**RE: ENGINEER'S CERTIFICATION FOR LOT 25, RICHFIELD (C-17/D2A29)
RECEIVED APR 6, 1999 FOR CERTIFICATE OF OCCUPANCY
ENGINEER'S STAMP DATED 04-05-99**

RE: DRAINAGE PLAN FOR LOT 25 RICHFIELD INDUSTRIAL PARK (C17-D2A29)
ENGINEER'S STAMP DATED 4/6/98

DRAINAGE AND GRADING PLAN
FOR
LOT 25, RICHFIELD INDUSTRIAL PARK
ALBUQUERQUE, NEW MEXICO

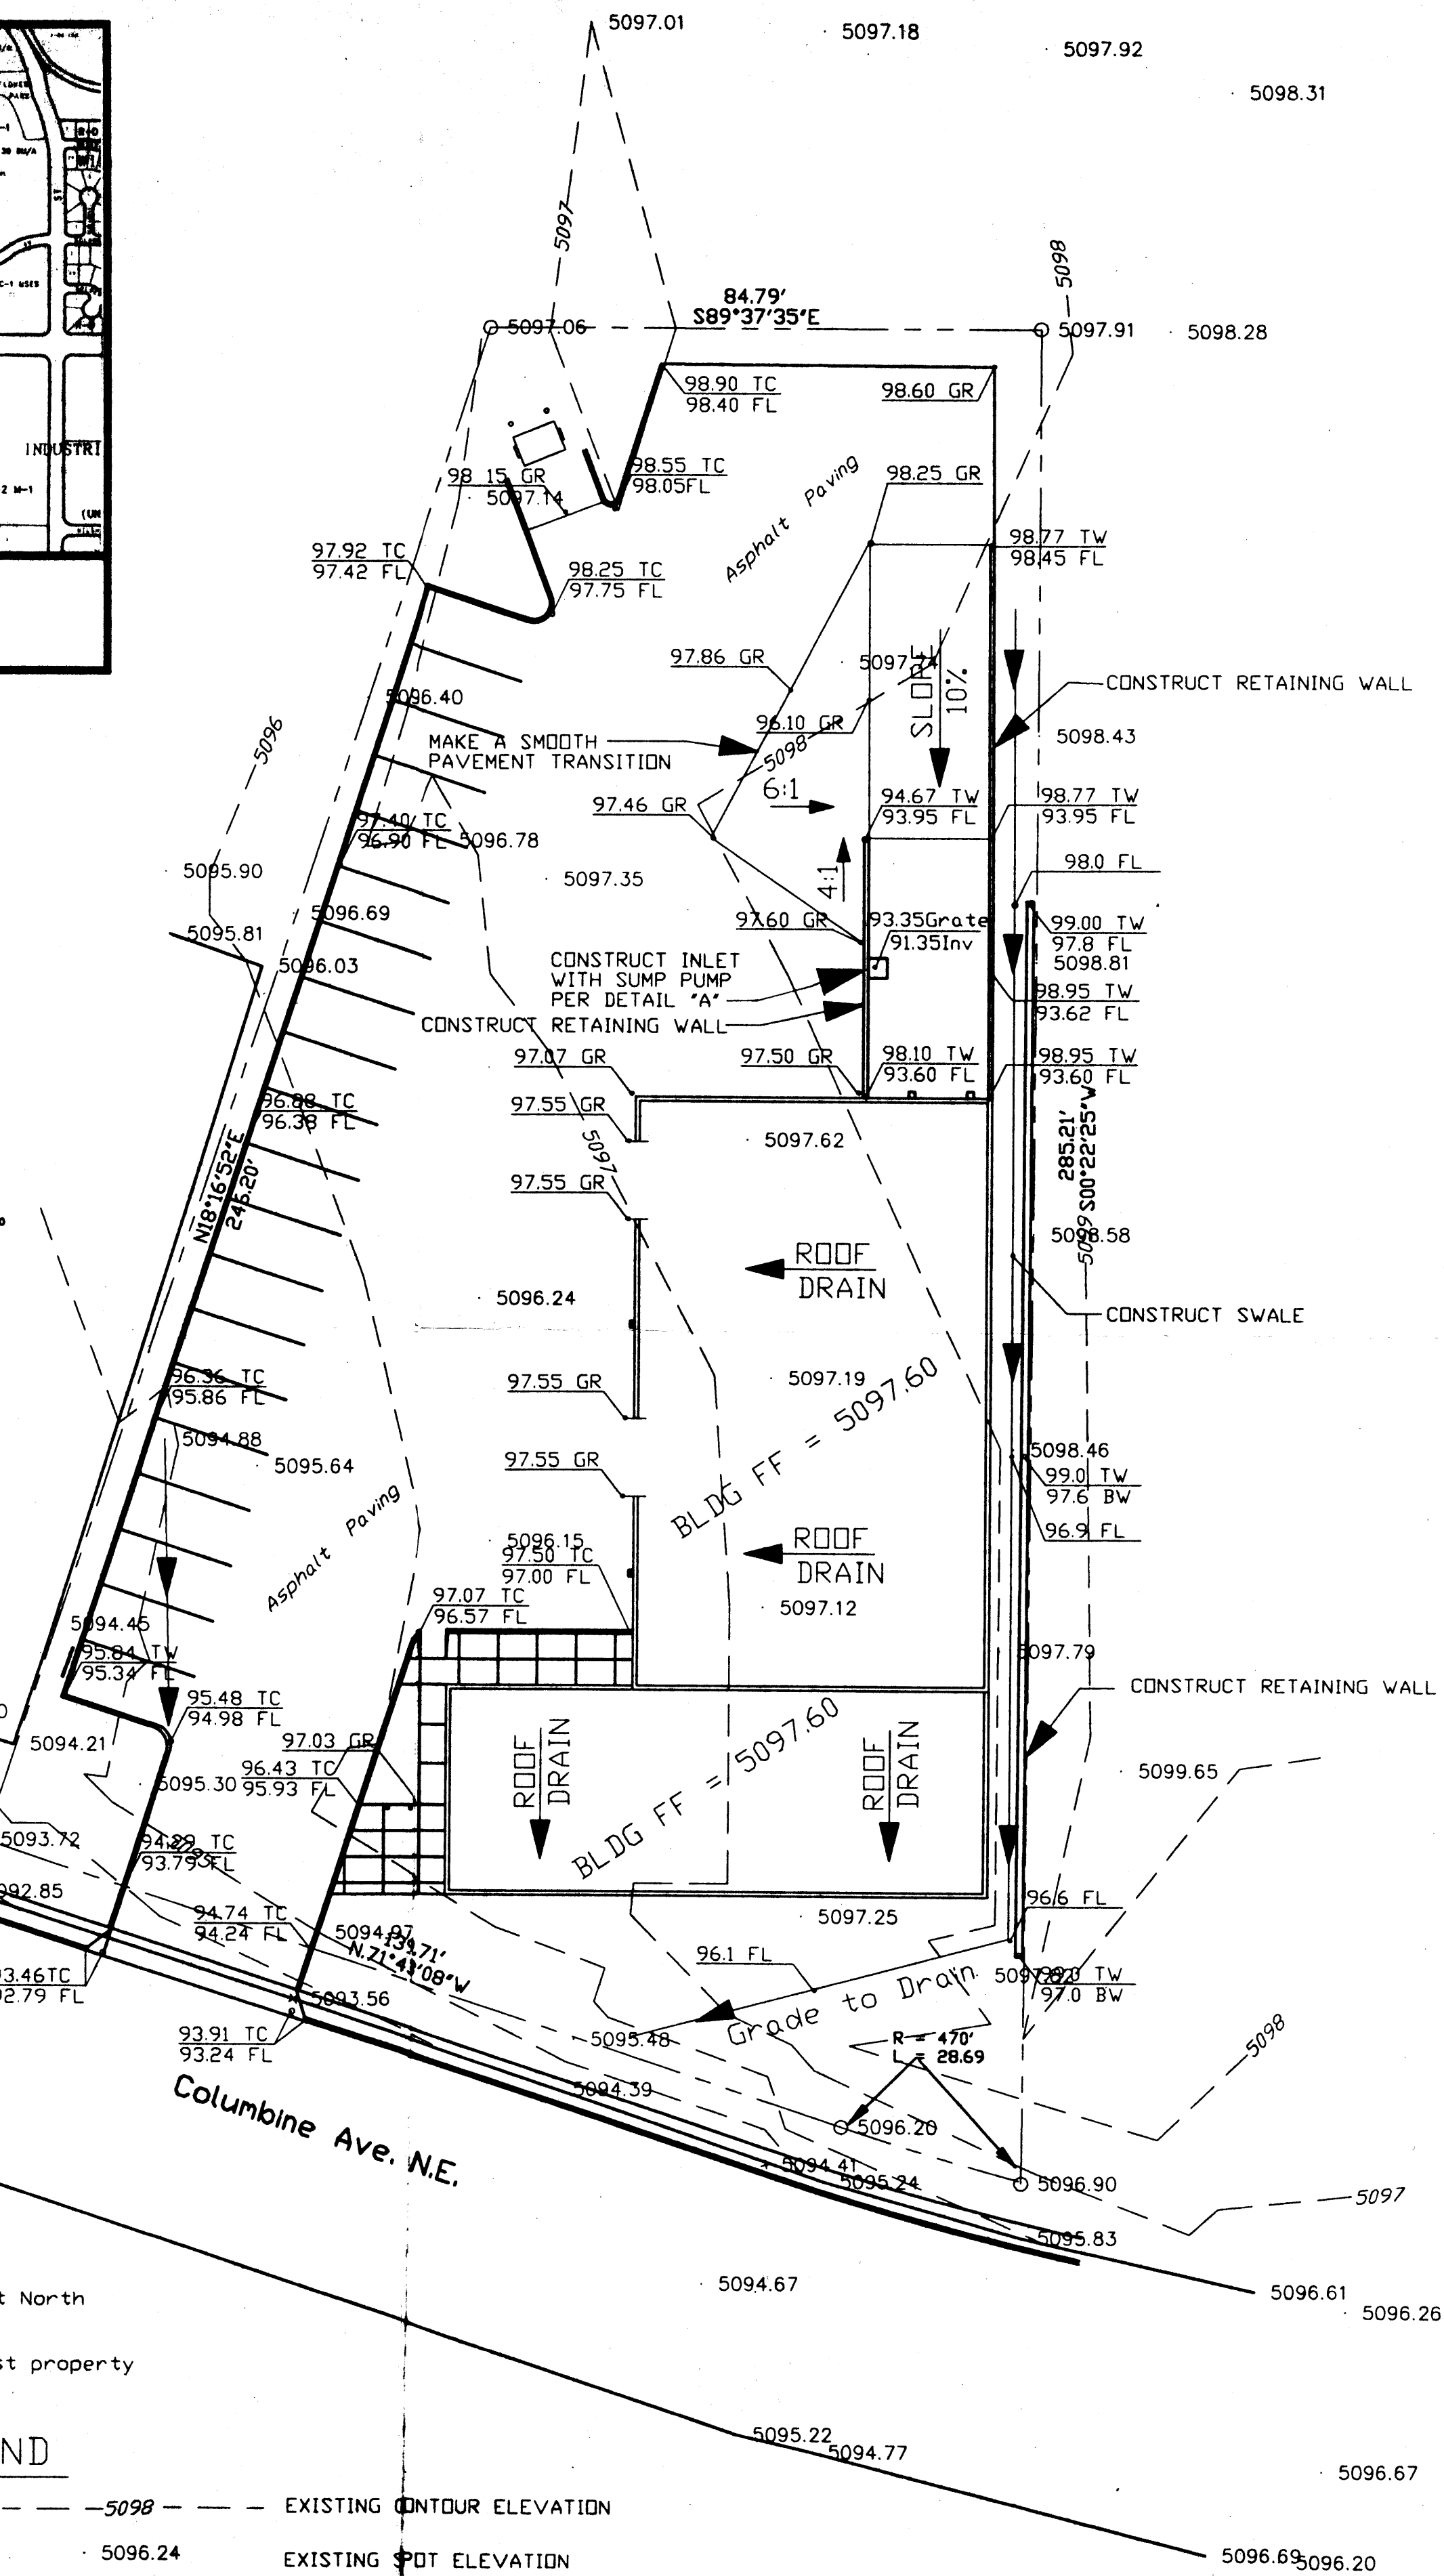
Based on the information provided on your April 7, 1998 submittal, the above referenced site is approved for Building Permit. Please advise your client that he will have to provide a curb notch to allow the run-off from the South side of the building to exit unto the paved area.
